PLANNING AMENDMENT

WESTON VILLAGE HALL STEERING
COMMITTEE

WESTON ST MARK PRIMARY SCHOOL PLAYING FIELD

SITE FOR CONSTRUCTION OF
A NEW VILLAGE HALL

REVISED PRELIMINARY STUDY FOR LOCATION OF BUILDING

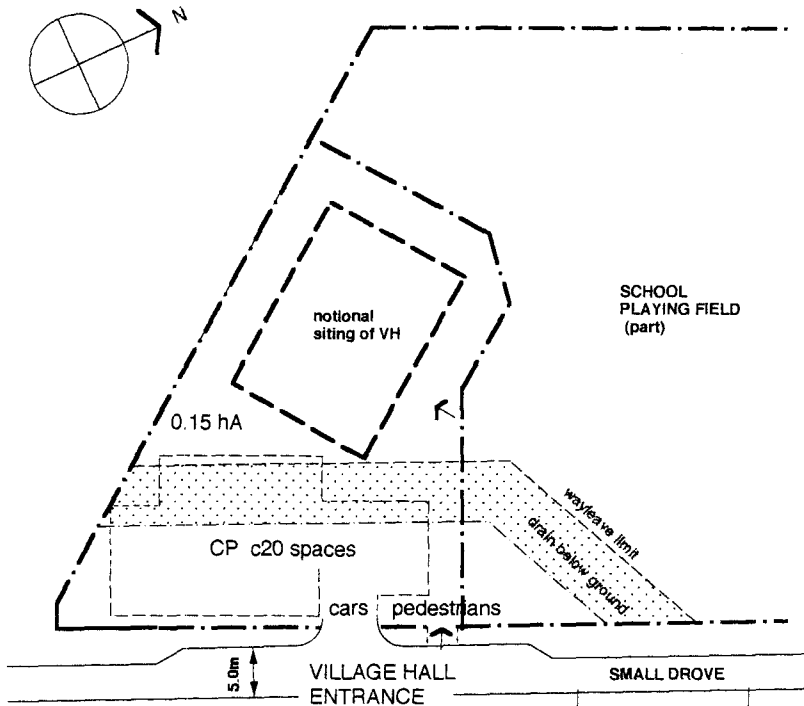
WIDENING OF MAIN ROAD
TO 5.0M. OVER A 40M LONG
SECTION OF ROAD AT ENTRANCE
TO SITE
